From: [Tim Colless](#)
To: [Simon Truong](#)
Cc: [Amy Watson](#)
Subject: RE: ECRC s.96 (SSD-5175)
Date: Tuesday, 15 March 2016 3:42:08 PM

From: Tim Colless
Sent: Tuesday, 15 March 2016 11:55 AM
To: Simon Truong
Subject: ECRC s.96 (SSD-5175)

Figure 9: Extract of proposed bulk earthworks plan showing pad sites and levels

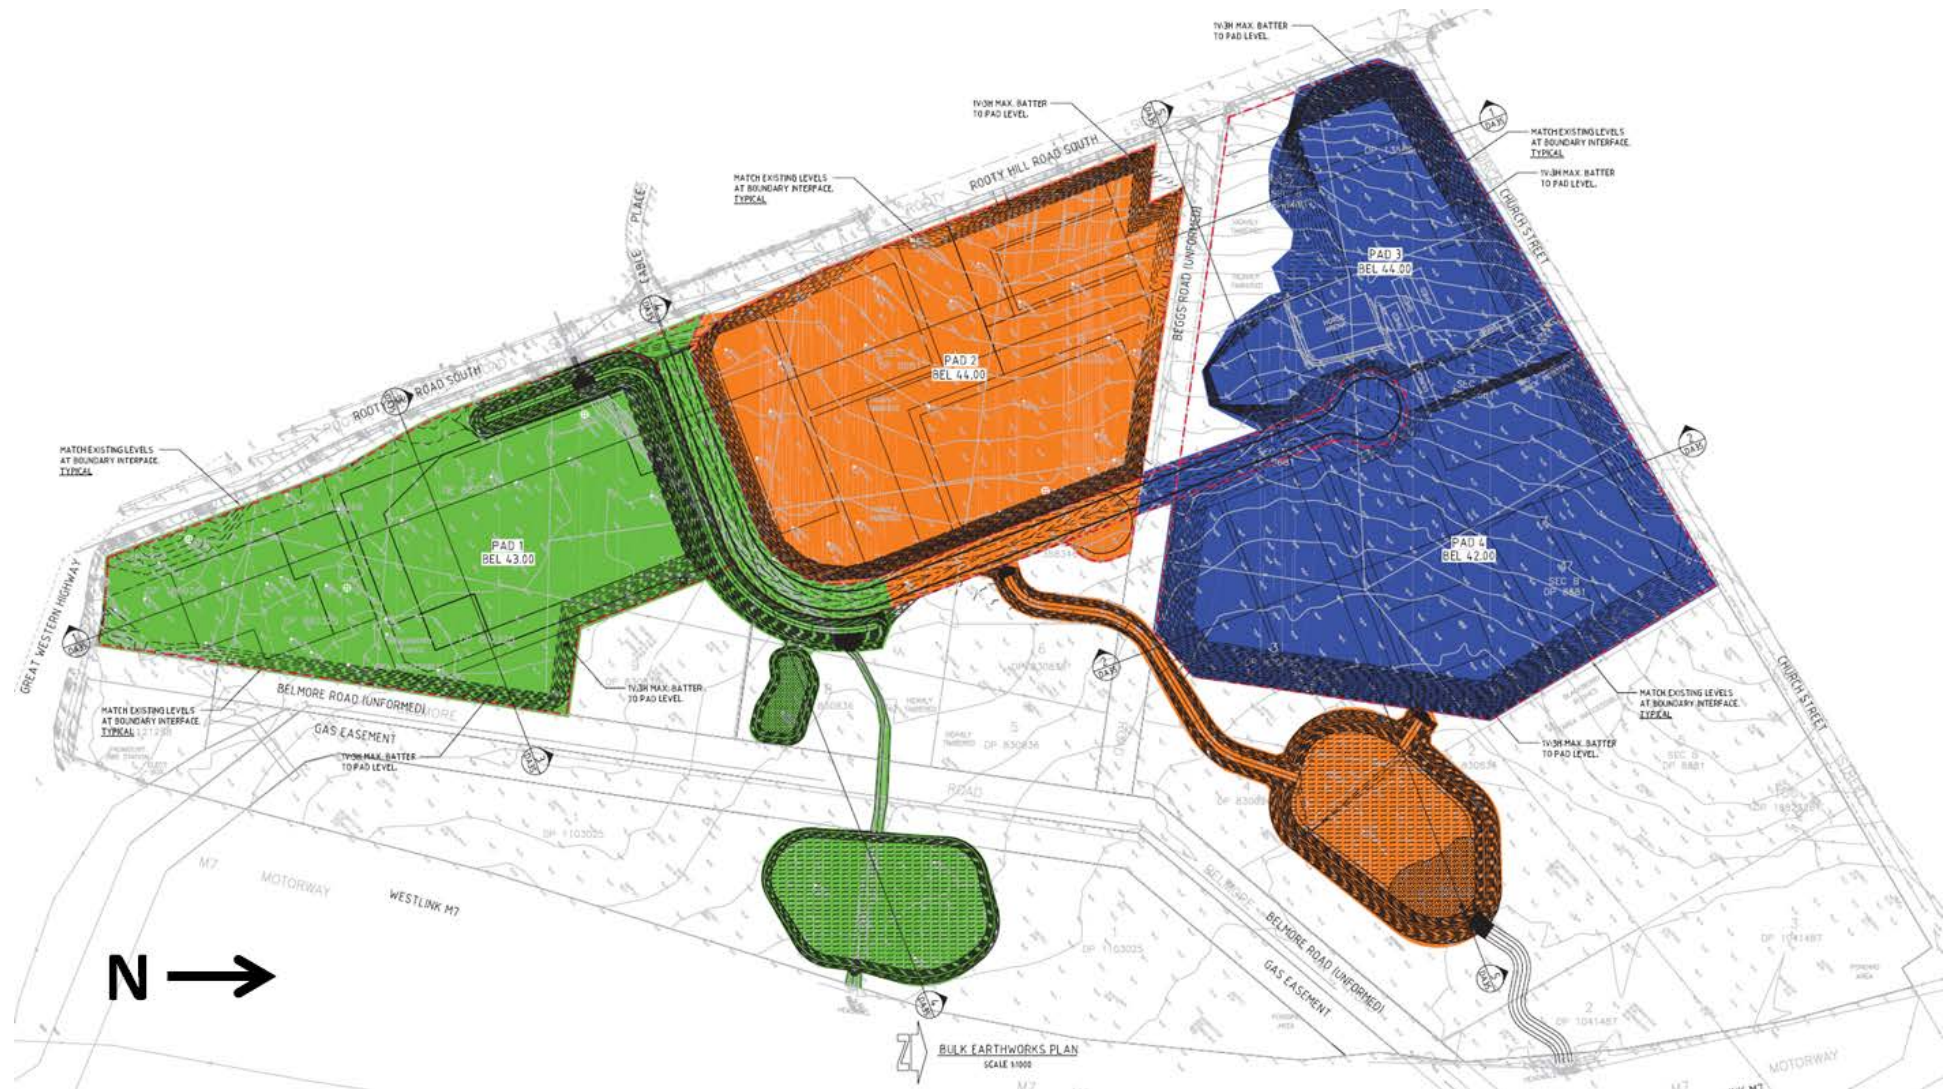
PAD 2 may have a significant impact on the Beggs Road pedestrian link alignment and the remaining cottage located adjacent to the remnant bushland in the centre of the site. Consideration should therefore be given to adjusting the boundary alignment of the 1.5m -3m high retaining wall, in the north west corner of PAD 2, so that a better transition is provided adjacent to the remnant bushland.

- BULK EARTHWORKS PLAN (CO12693.00-DA30 Issue B) and BULK EARTHWORKS SECTIONS SHEET 1 (CO12693.00-DA35 Issue B) propose batters at the north-west corner of Lot 2 with levels generally similar to those on Beggs Road and at the private residence.
- The 'Response to Submissions' letter from JBA (January 2016) advises :

"It is proposed to increase the height of PAD 2 from an average RL43 to an average RL44. The proposed PAD level is generally consistent with the existing ground levels in the area close to the remnant bushland (refer to the Site Survey prepared by Land Partners, submitted with the initial SSD application) and is not expected to generate any additional impacts beyond those considered during the original assessment."

Basically the retaining was removed.
